Ref: D2011/628

**COCA COLA AMATIL PLASTICS MANUFACTURING FACILITY
– Construction and Operation; Application Number: 10_0125**

I refer to your letter received 14 December 2010 inviting the Sydney Catchment Authority (SCA) to make a written submission on the Environmental Assessment (EA) for the Coca Cola Amatil Plastics Manufacturing Facility.

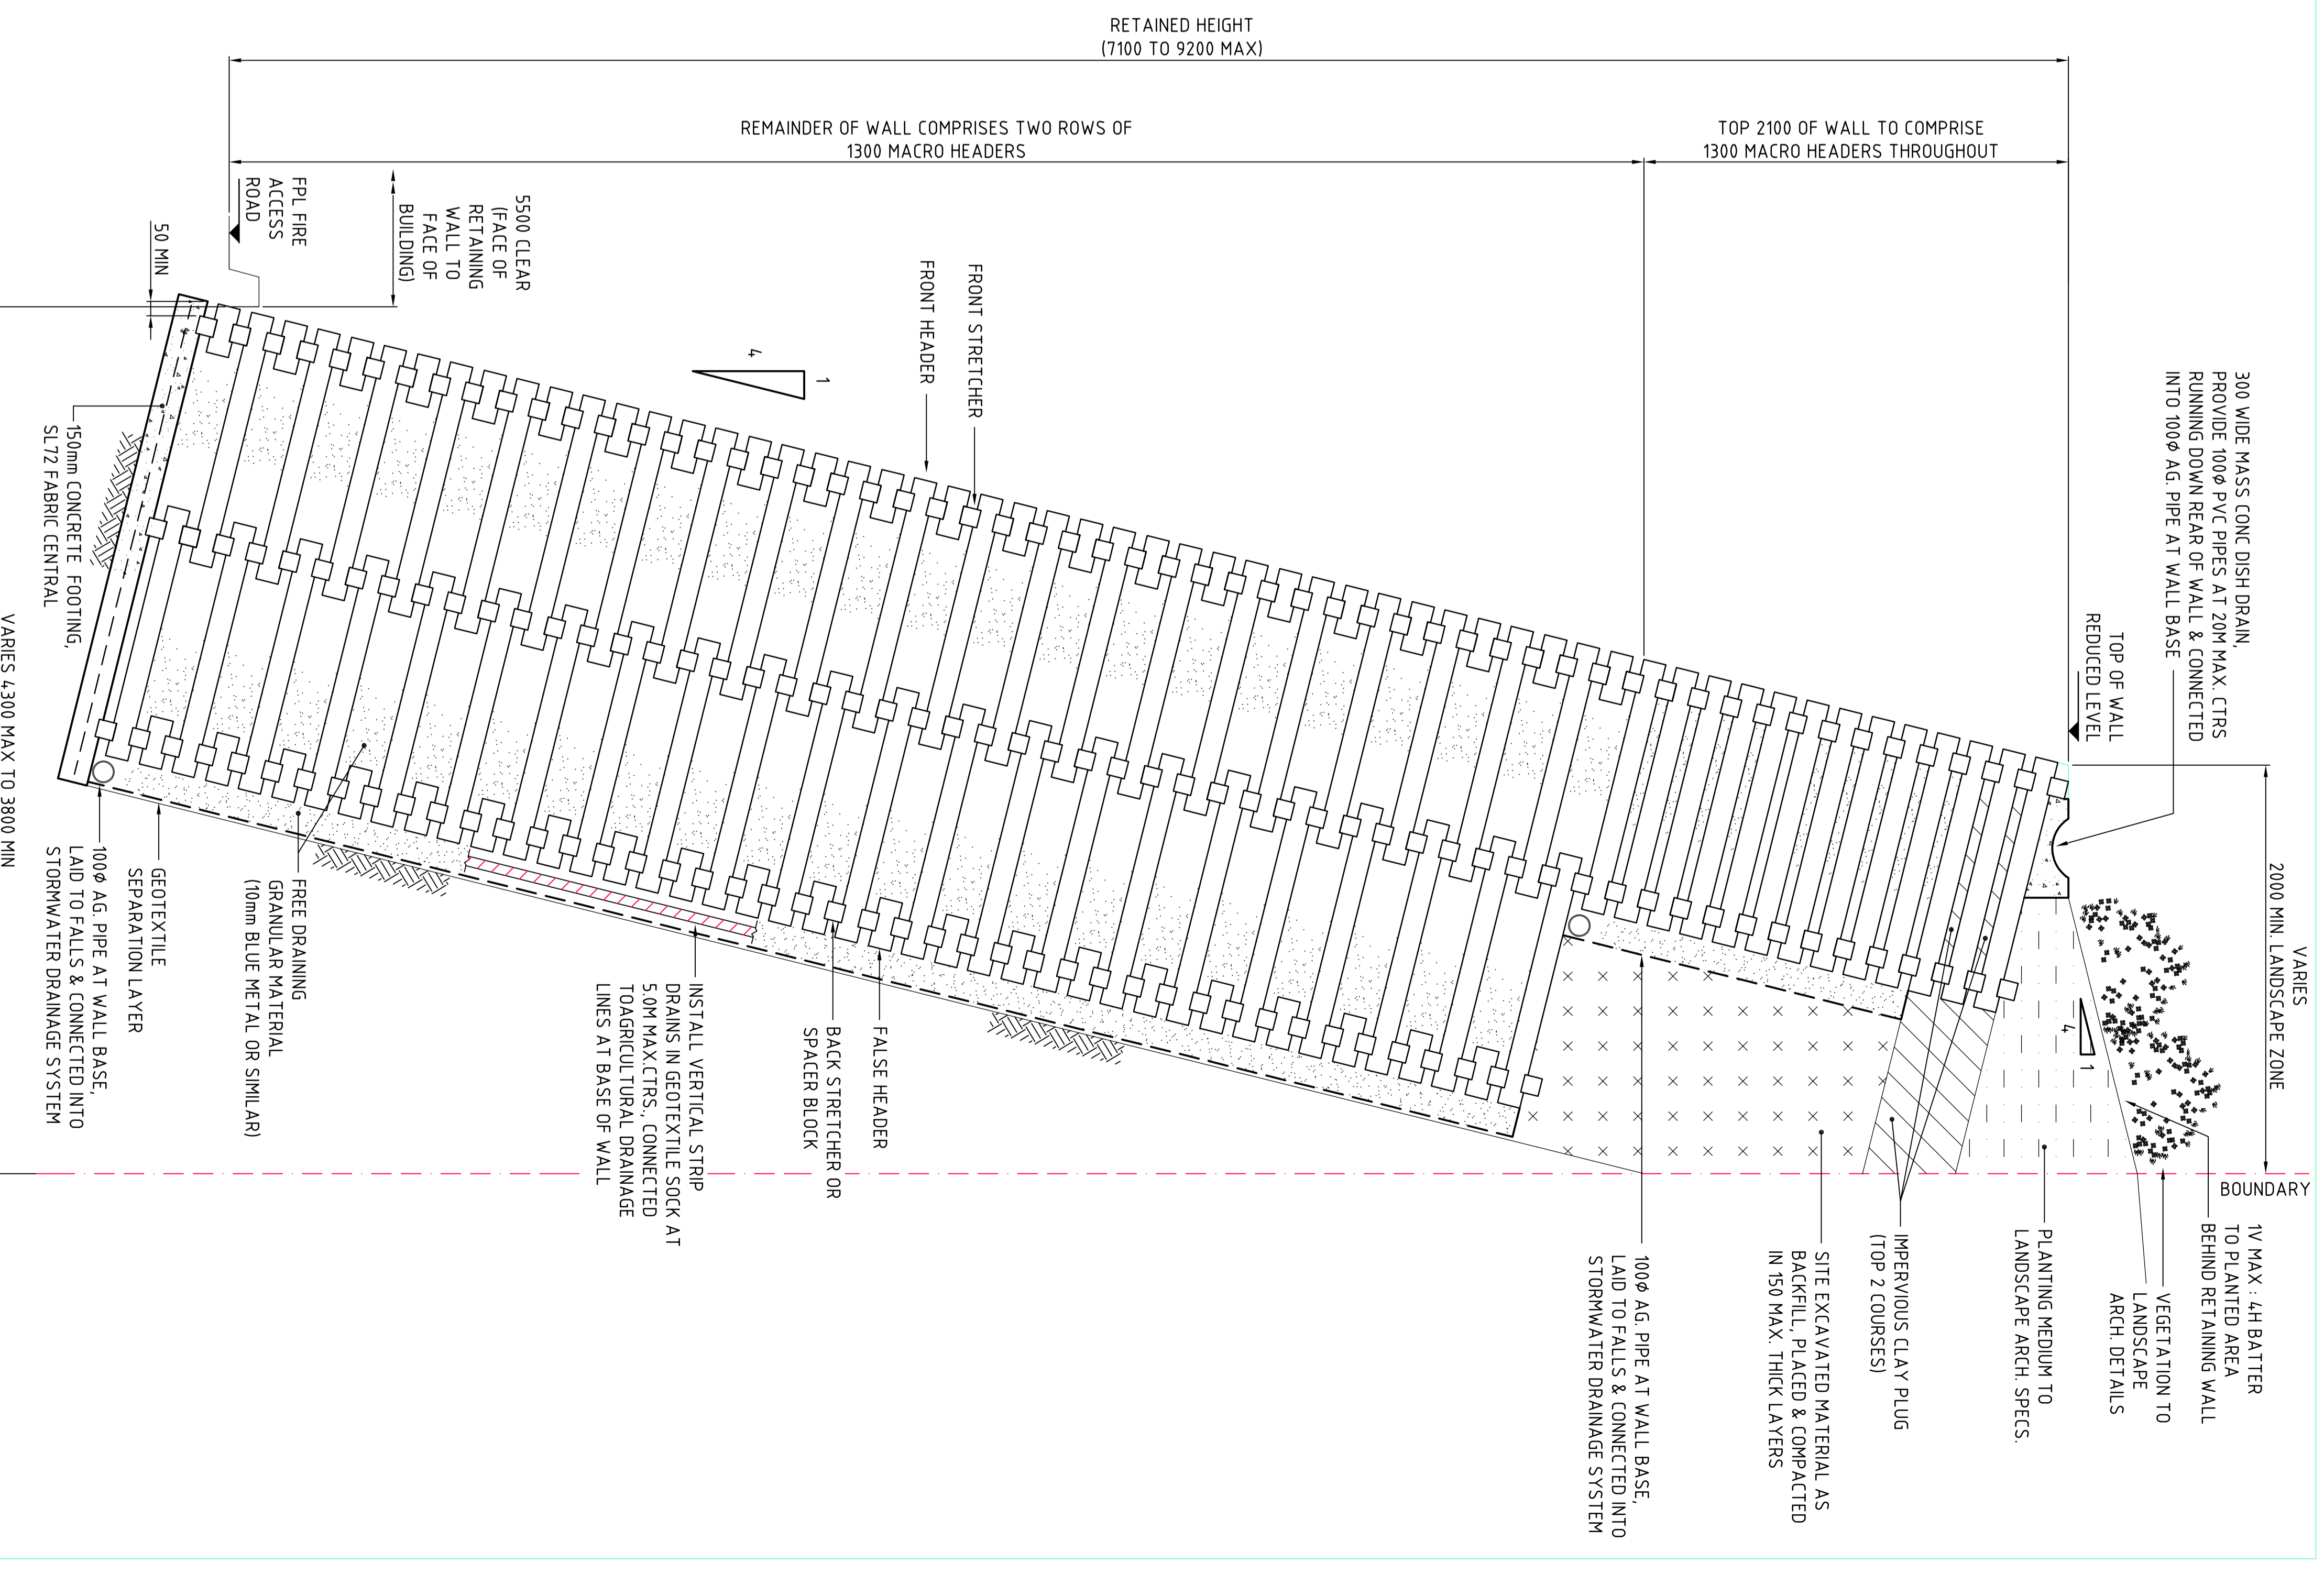
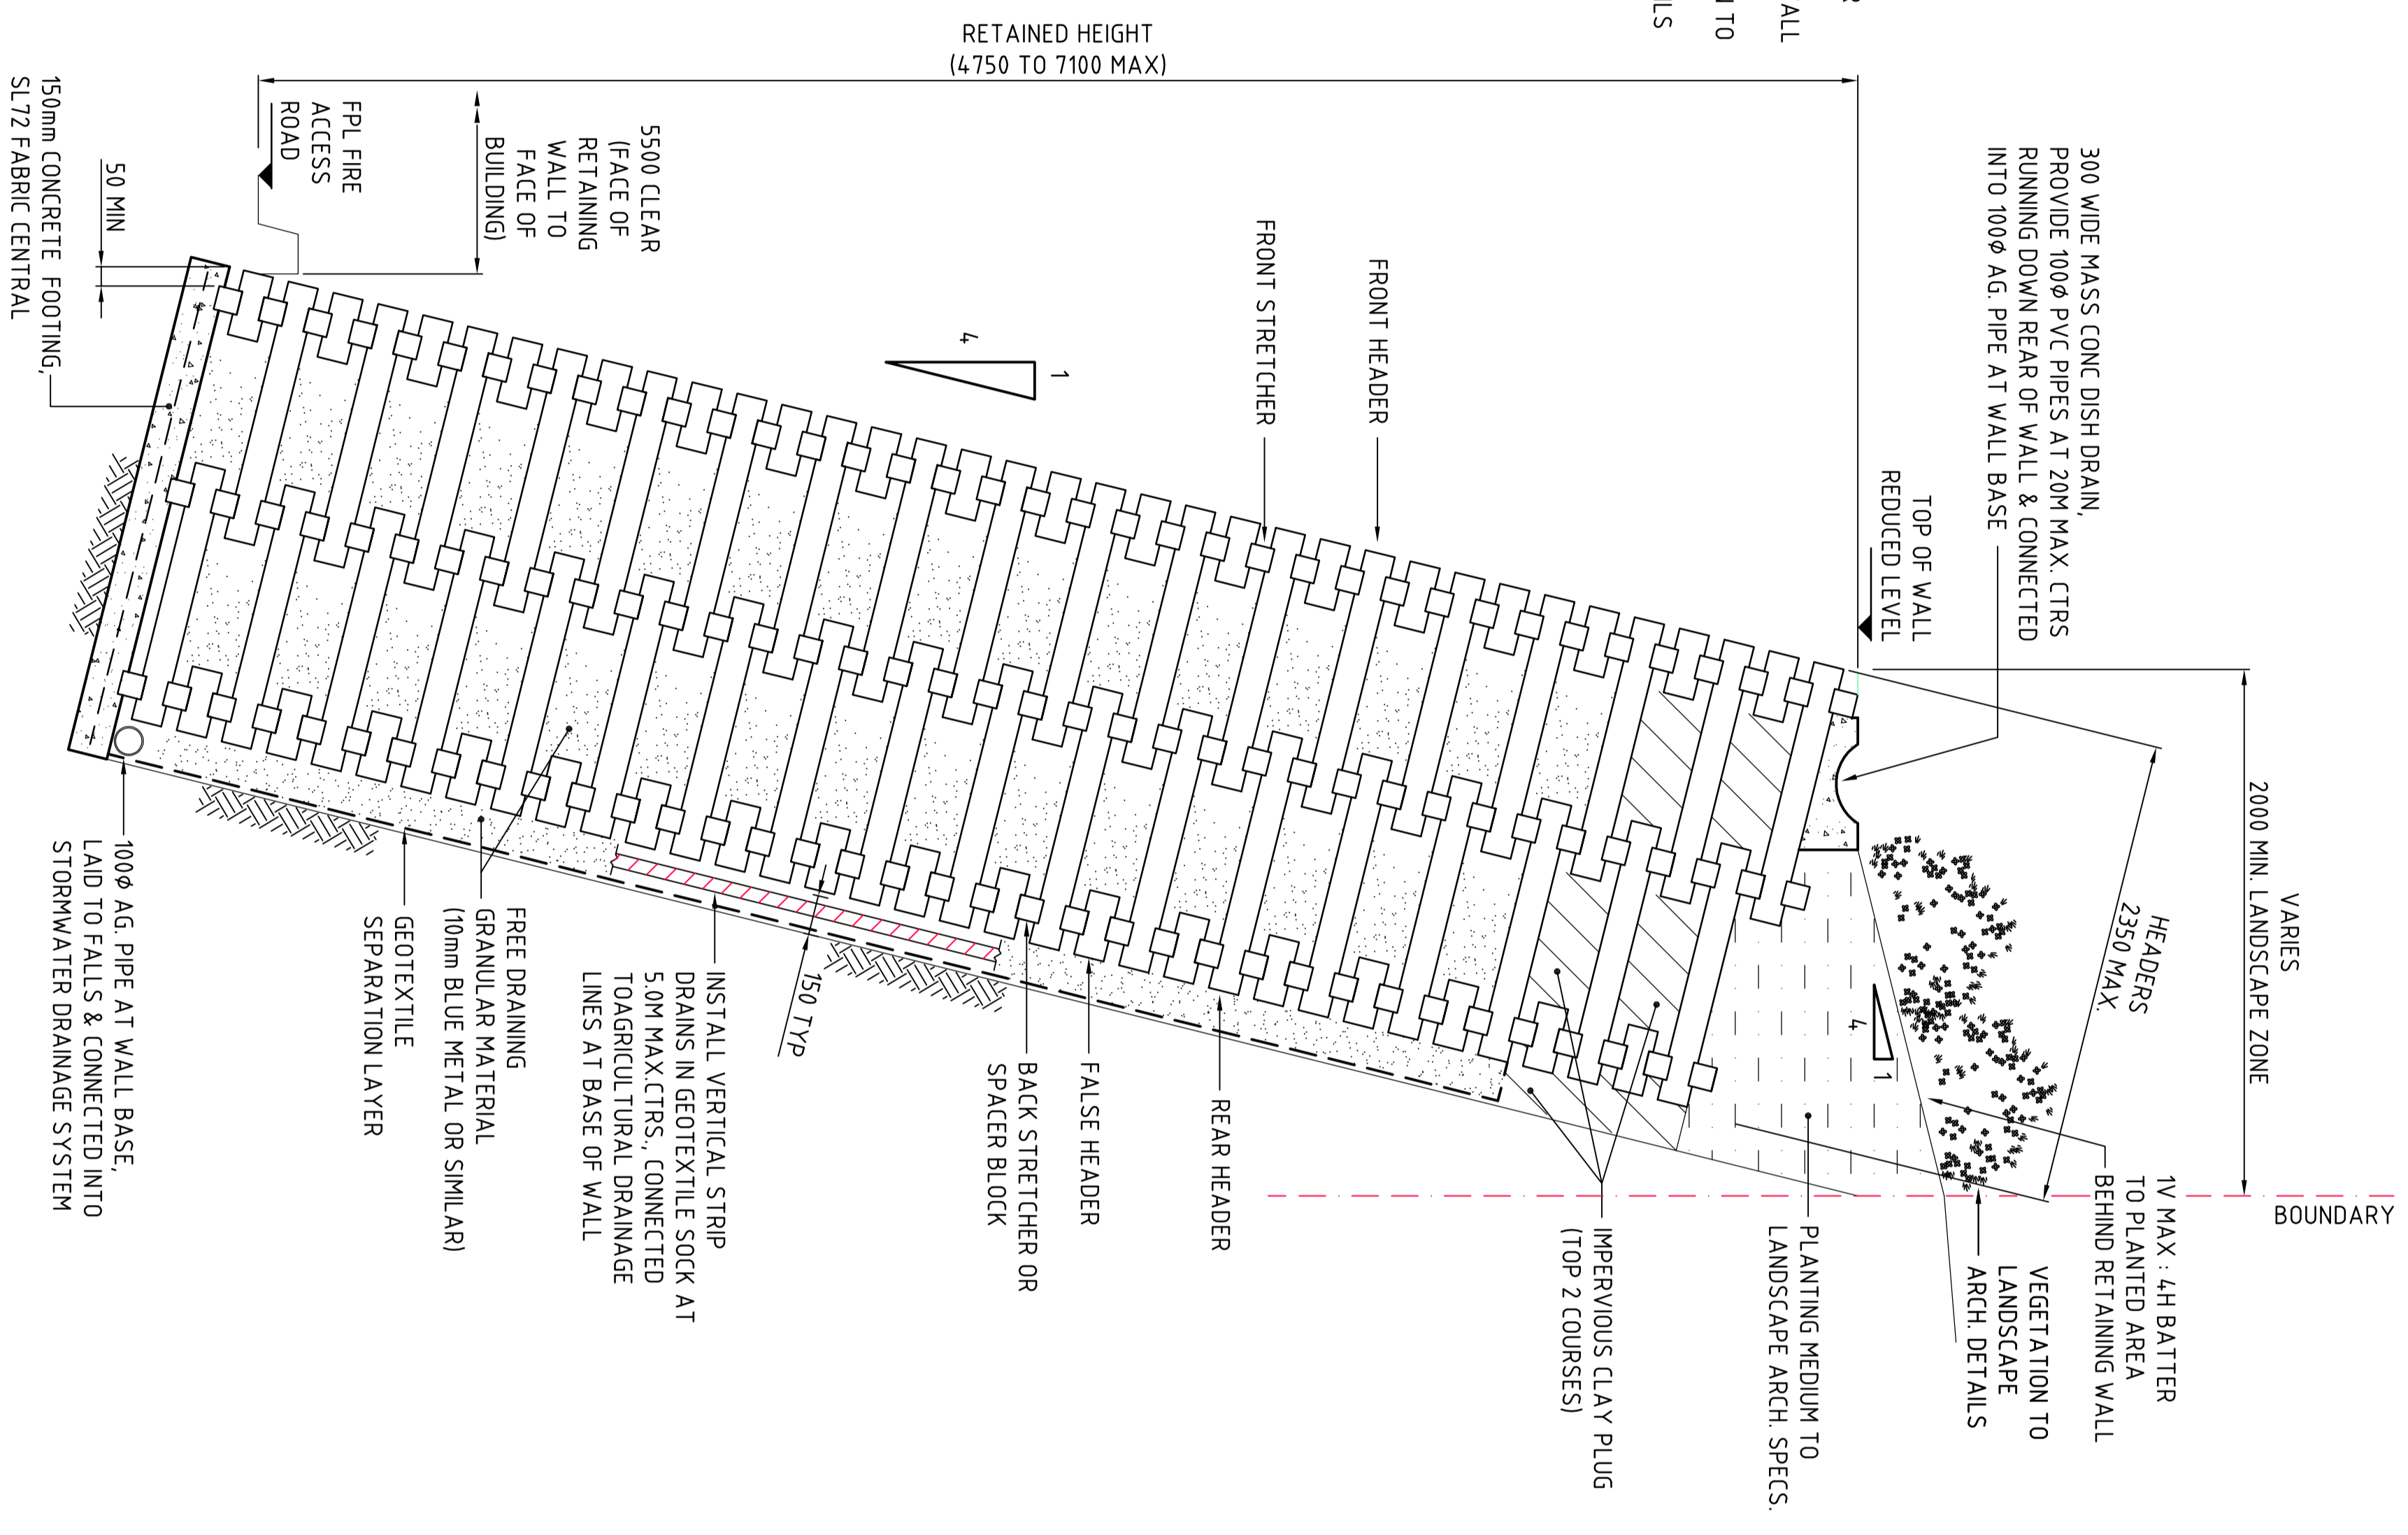
The concept layout plan (No. Co9170.05-CSK02) displayed in Appendix 13 proposes a retaining wall along the boundary fence along SCA land. The SCA requests that the following condition be included in any approval of the development:

- *all work in relation to the retaining wall along the boundary fence along SCA land is constructed in a manner consistent with the drawings provided;*
- *work is undertaken solely within land owned by the proponent. SCA does not permit any entry on SCA land without prior specific approval;*
